Application for Removal or Variation of a Condition following Grant of Planning Permission or Listed Building Consent

Blunts Avenue

Erection of part single storey, part two storey side and rear extension.

12171/APP/2024/2831

Ground Floor Proposed

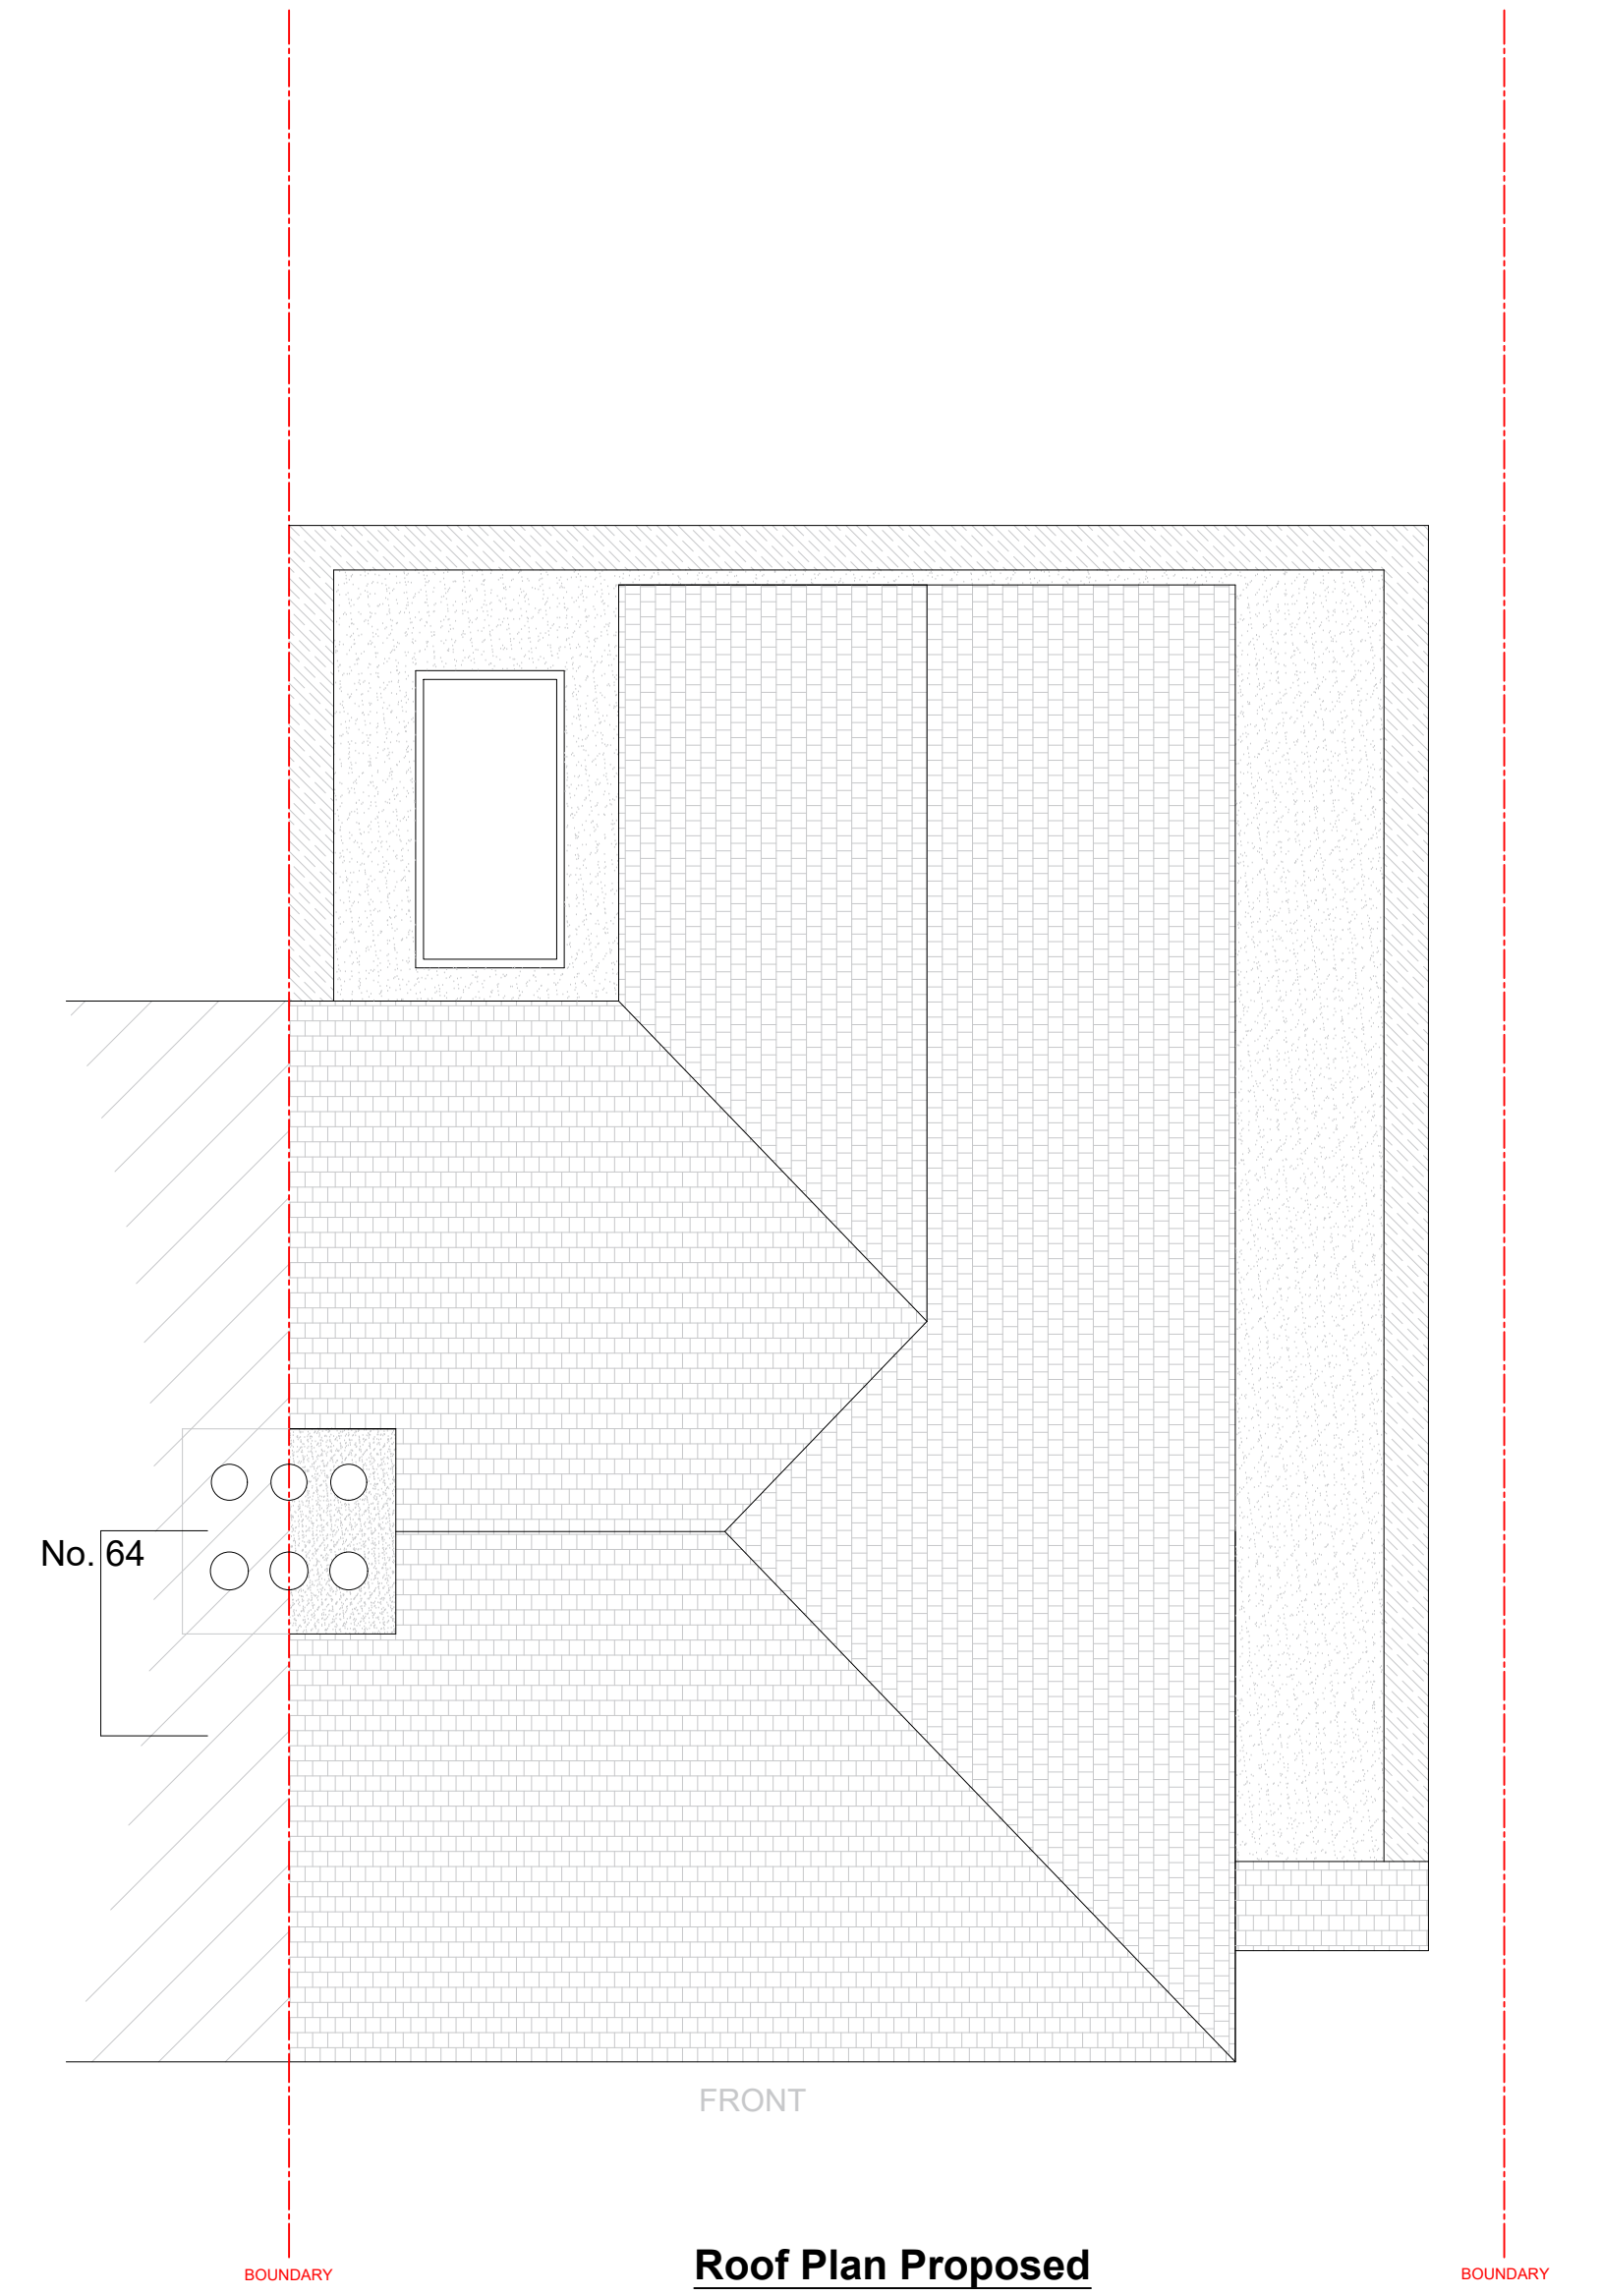
We would like to replace flat roof to proposed first floor rear extension with pitched gable roof

We do not have enough headroom in new bedroom and would like to provide vaulted ceilings to address this
